WYKHAM PARK FARM, A361 BLOXHAM ROAD, BANBURY

Road Safety Audit Stage 1 Response Report

Doc ref: WPF-HYD-XX-XX-RP-C-0008-P02 Stage 1 RSA Response

UNCONTROLLED CROSSING

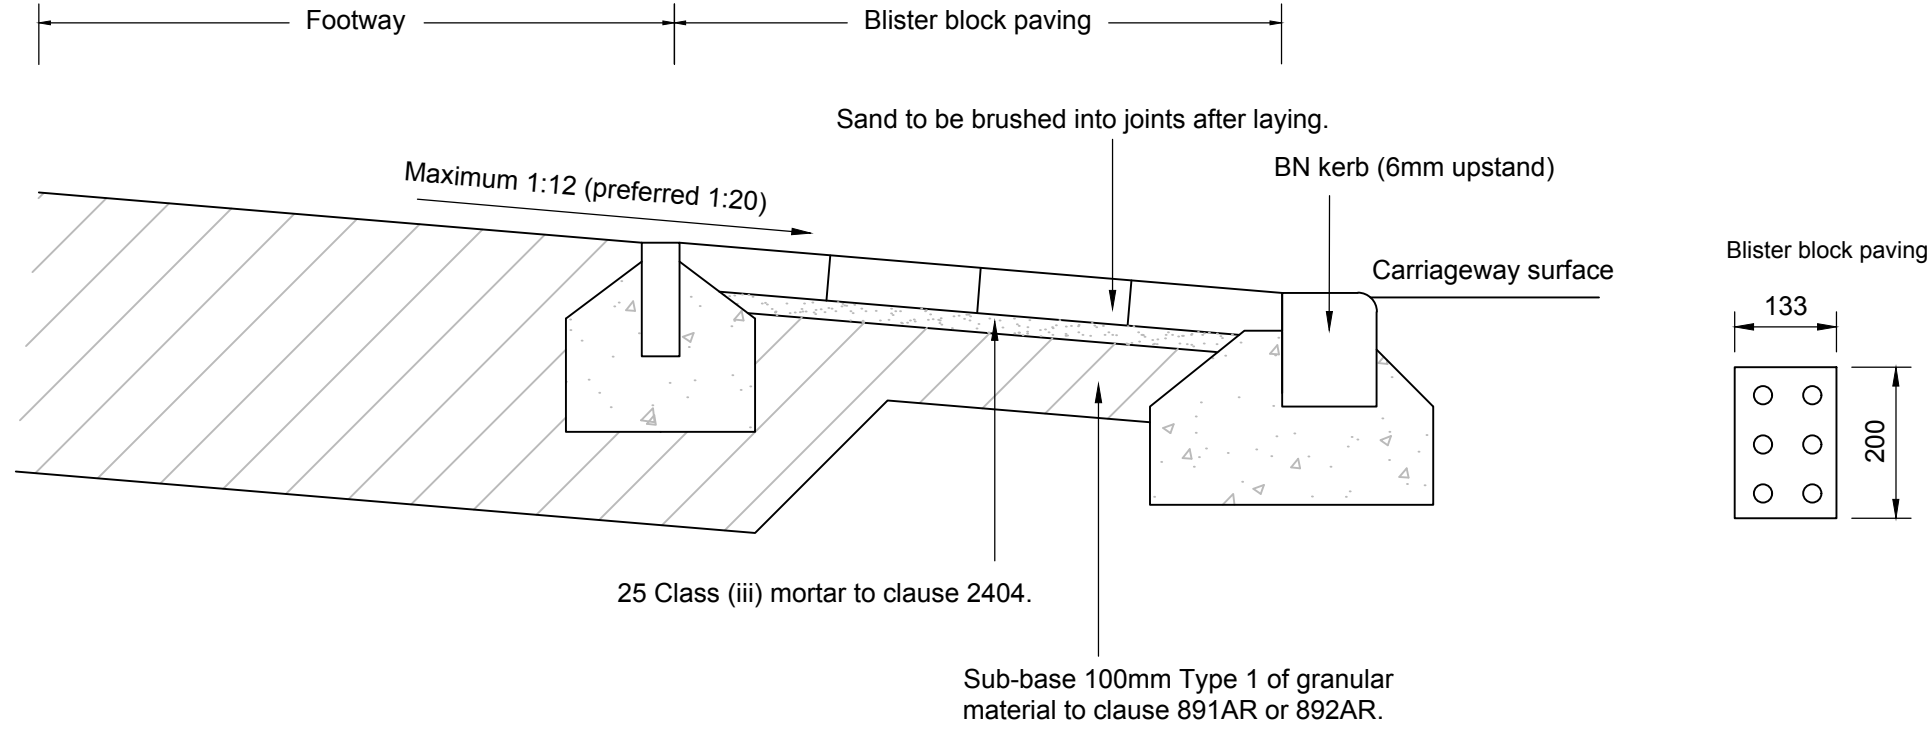
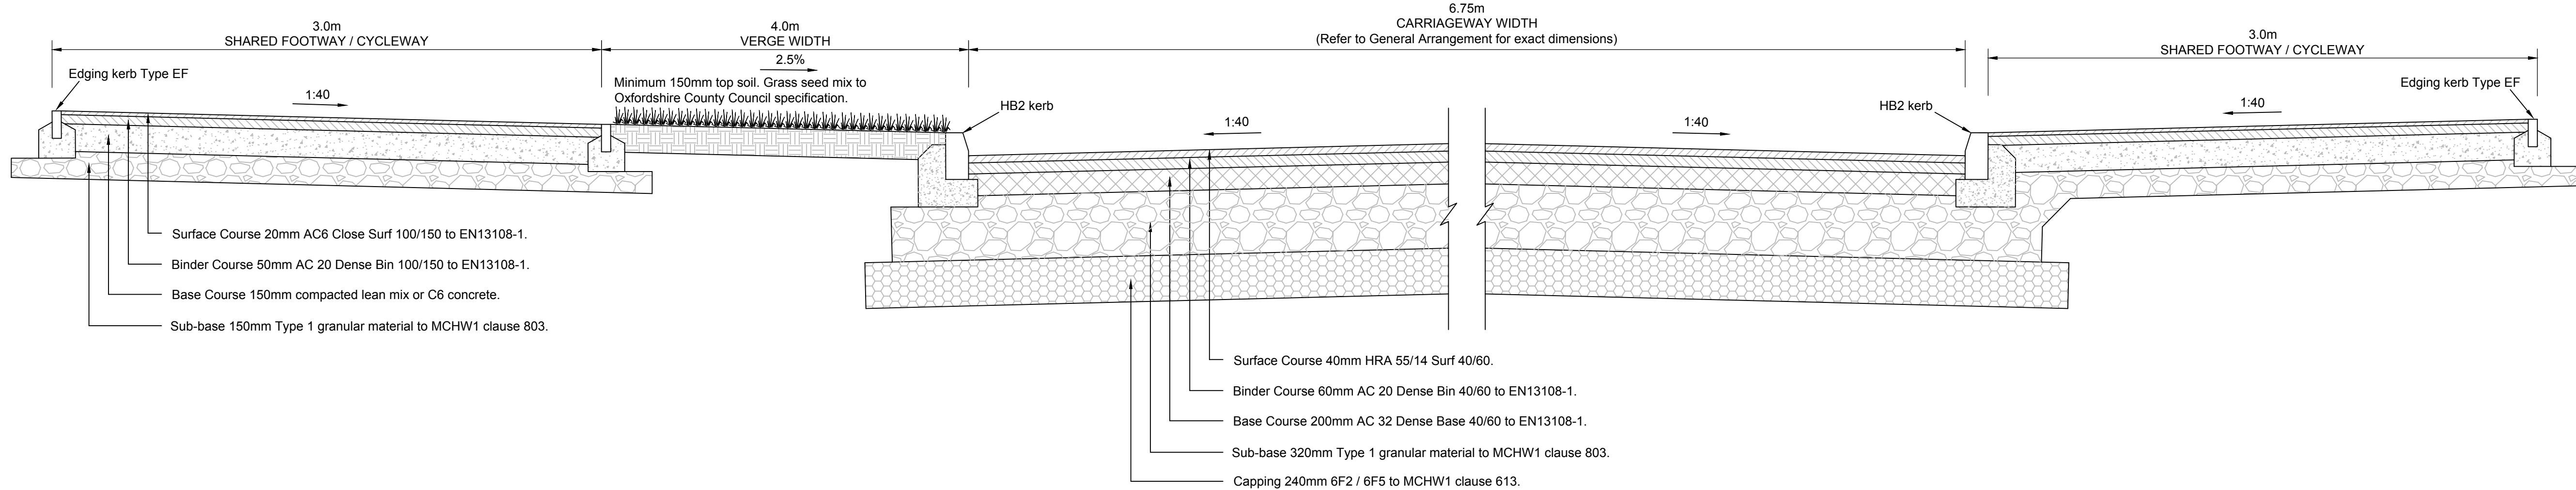
3.1	It is recommended that tactile paving is provided across the side roads in accordance with current guidance for in-line uncontrolled crossings.	Agreed. Tactile paving at priority junctions on the north side of the Spine Road increased to 3-deep.	Agree with action and response.	No action required.

3.4	It is recommended that tactile paving is provided in accordance with current guidance for uncontrolled crossings.	Agreed. "L" shaped tactile paving removed at pedestrian refuges.	Agree with action and response.	No action required.

3.5	It is recommended that the stem of the "L" shaped tactile paving extends to the back edge of the footway and should be on the right hand side of the crossing point. The tactile paving across the cycle crossing point should be removed in accordance with TSM Chapter 6. It may be appropriate to install road markings to diag. 1057 to highlight the cycle side of the crossing. The black/white stripes associated with the zebra part of the parallel crossing should be installed.	Agreed. "L" shaped tactiles extended to back of shared footway and zebra stripes added for southern roundabout crossing. No tactile paving is proposed on the cycle side of the parallel crossing. Cycle marking diagram 1057 have been added on the carriageway surface to highlight the cycle crossing.	Agree with action and response.	No action required.
